MIDTOWN COLLECTION AT HANNAH RIDGE FILING NO. 2

CHUCK BROERMAN, RECORDER _____
DEPUTY _____
MIDTOWN COLLECTION AT HANNAH RIDGE FILING NO. 2
JOB NO. 1116.30
JANUARY 15, 2019
SHEET 1 OF 3

PLAT V_3 redlines 3.pdf Markup Summary

MIDTOWN COLLECTION AT HANNAH RIDGE FILING NO. 2
JOB NO. 1116.30
JANUARY 15, 2019
SHEET 1 OF 3

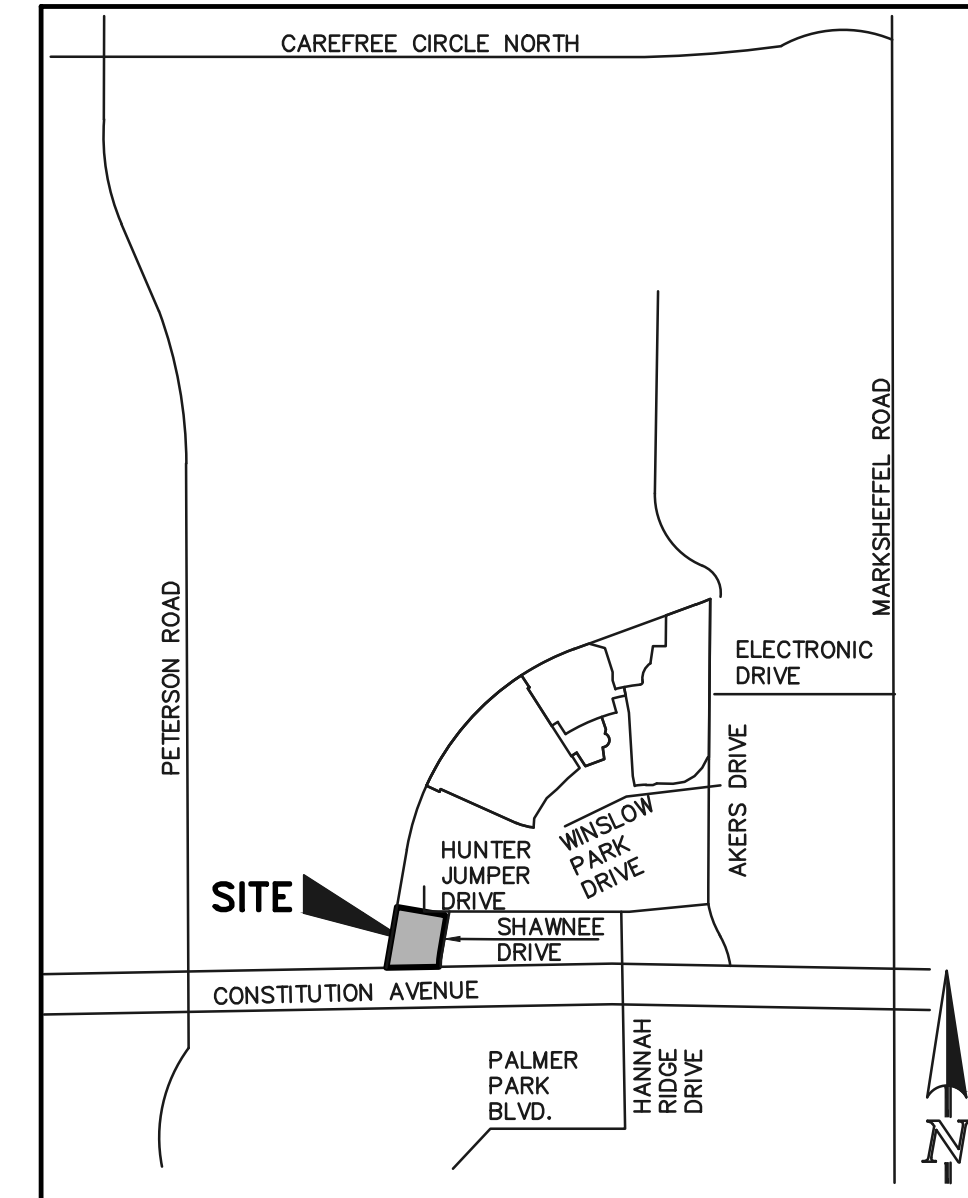
LOI states that one filing is in a District and the other plat filing is in the other District. Cimmaron Hills has commented that the fil 2 plat is within their District. This fil 2 plat is NOT in Falcon

Detention Pond Maintenance Agreement recorded at reception number.... ETC note please add.

Add the noise wall note: who is installing it and who is maintaining it please.
